MEMORANDUM

TO: Shukria Wiar, Planner
FROM: Lauren Swett, PE & Craig Sweet, EIT
DATE: February 27, 2017
RE: 185 Lancaster Street, Level III Site Plan Application

Woodard & Curran has reviewed the Level III Site Plan Application for the proposed project located at 185 Lancaster Street in Portland, Maine. The project involves interior renovations to an existing building for the use of Baxter Academy. Only minor site improvements are proposed.

BAXTER ACADEMY - INTERIOR FIT-UP

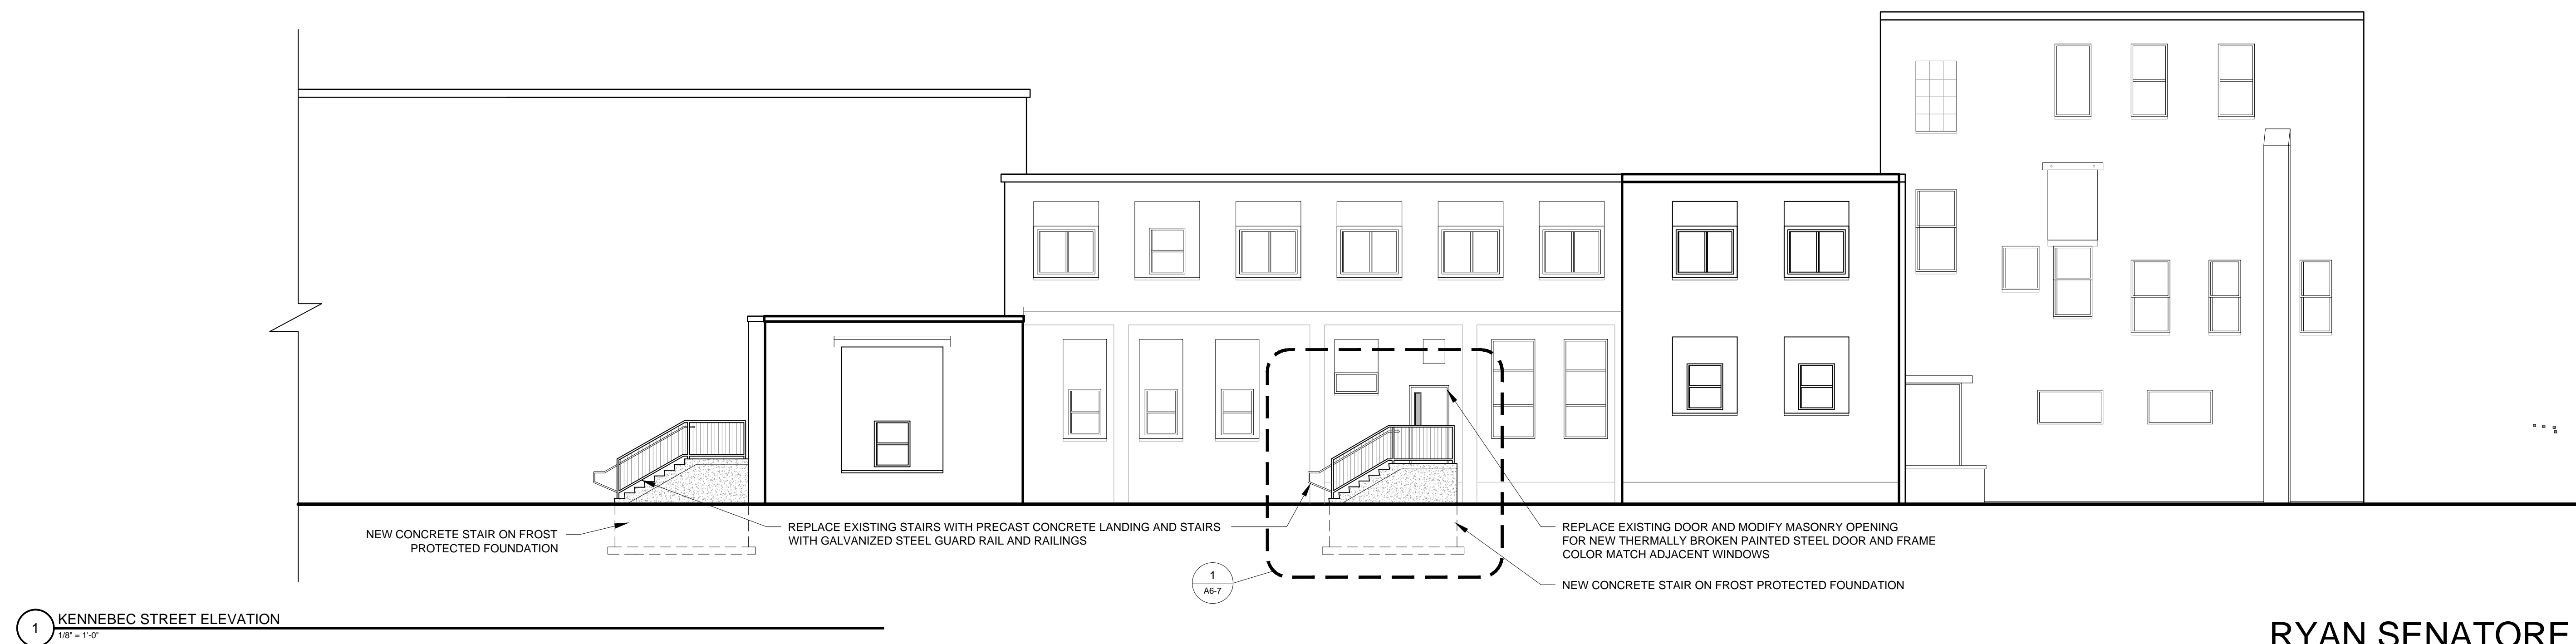
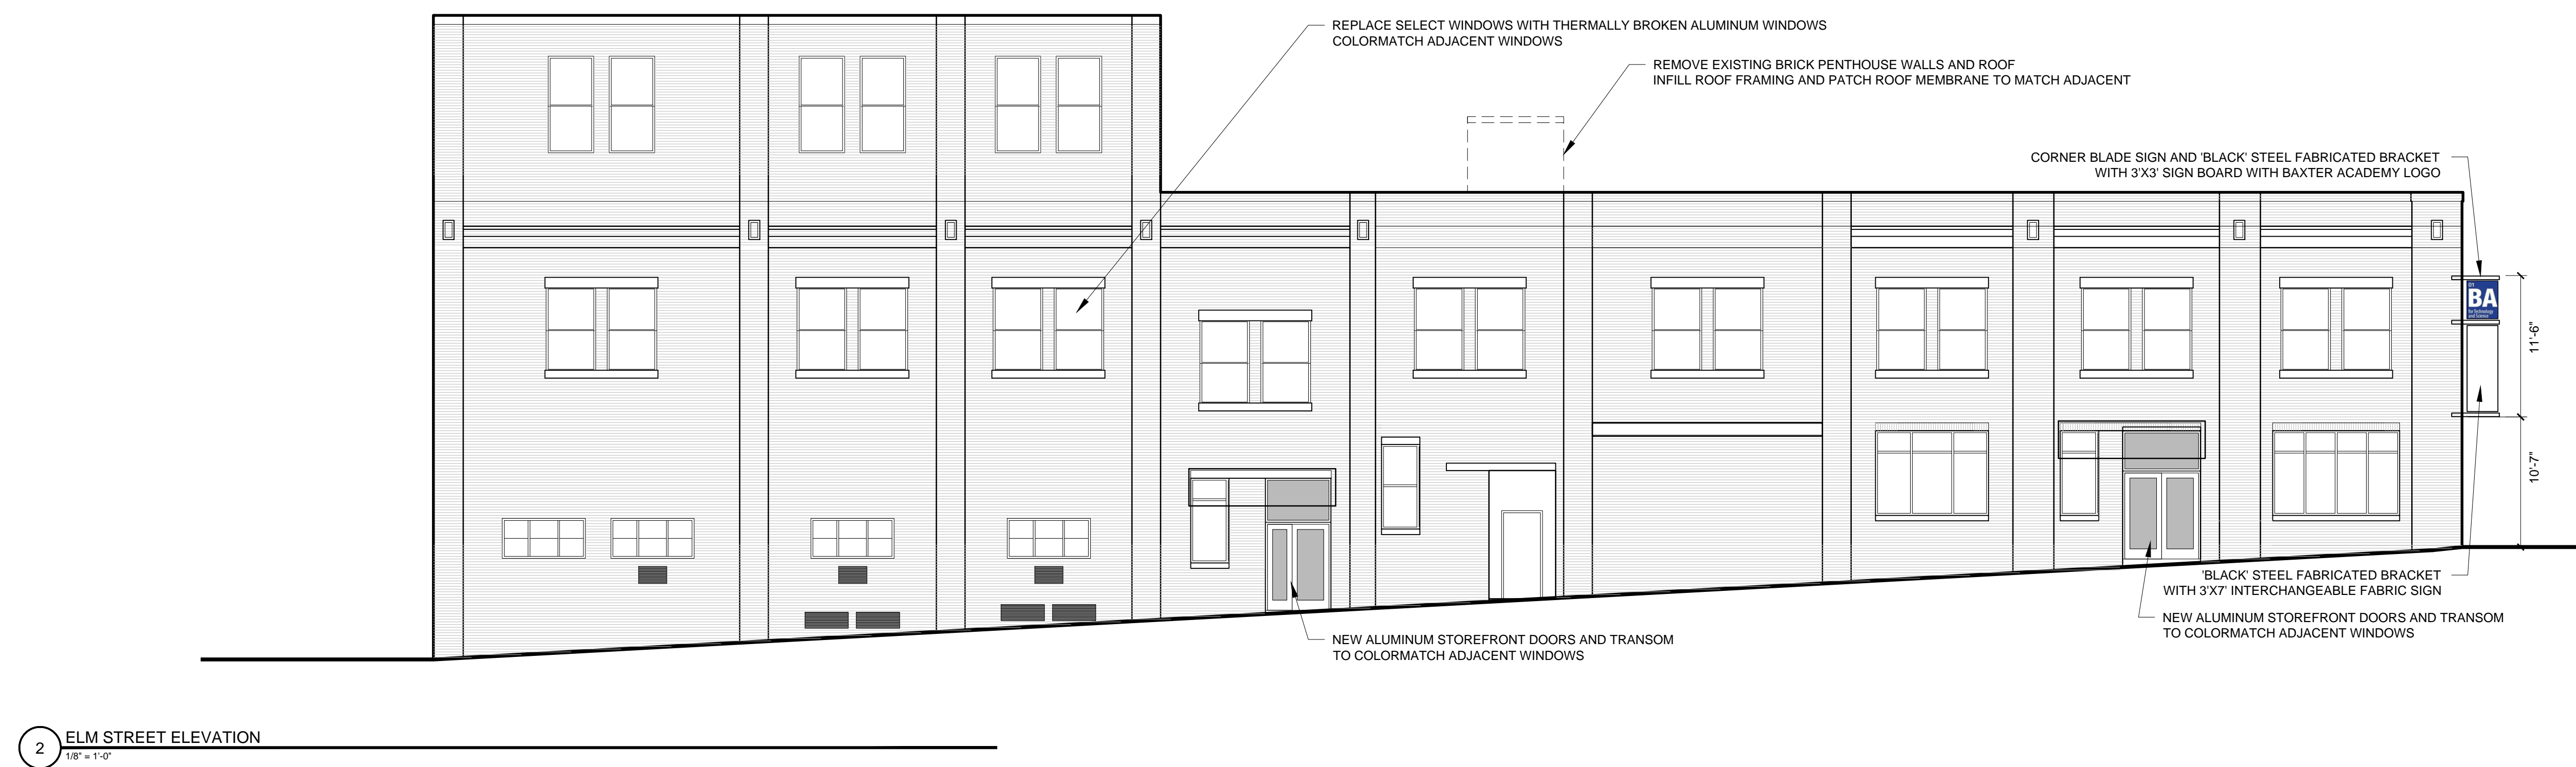
- 2) The Applicant should provide additional detail pertaining to stairway upgrades along the northwestern side of the building on Kennebec Street. Specifically, will any regrading or pavement replacement be required? The area appears to be close to the right-of-way, and potential impacts due to construction should be reflected. A site plan should reflect any of these changes or impacts.

Drawing file: Plans / 5. Grading Plan.pdf

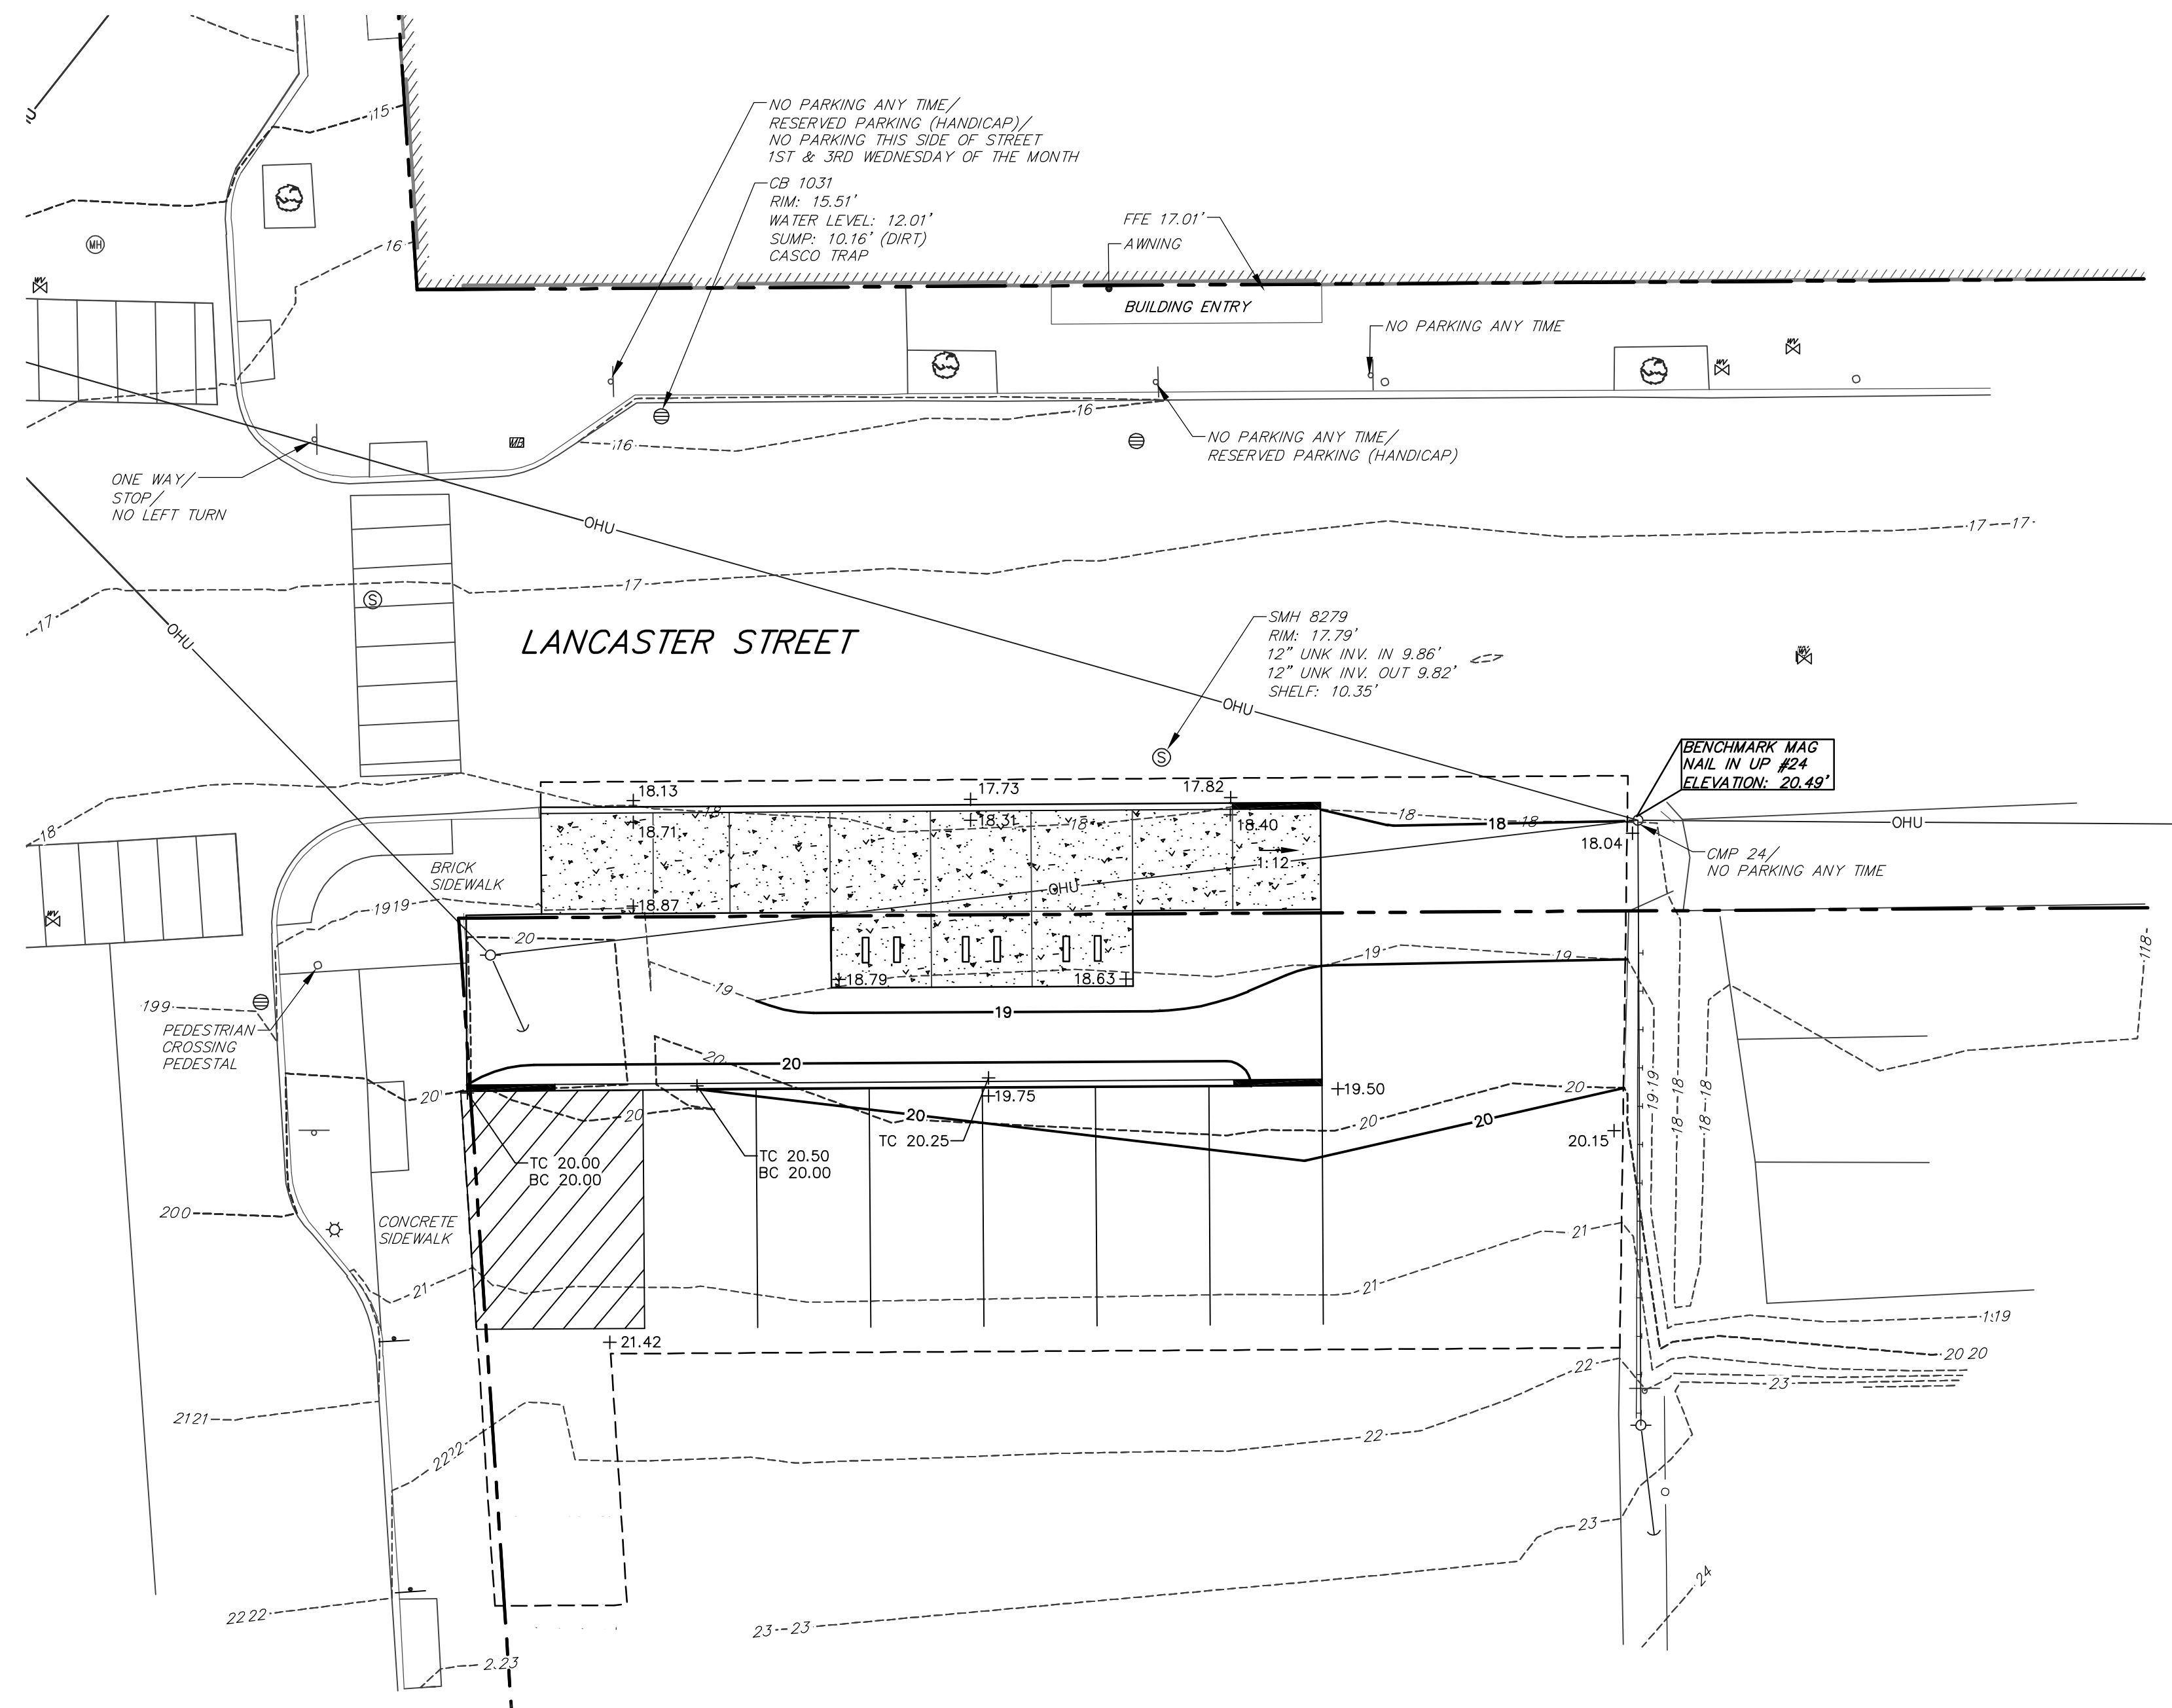
- 4) A survey of the overall area has been provided. The engineering plans provided for the Lancaster Street improvements should be updated to include the property/right-of-way lines such that it is clear what improvements are being done within the City right-of-way. These improvements must follow the City of Portland Technical Standards.
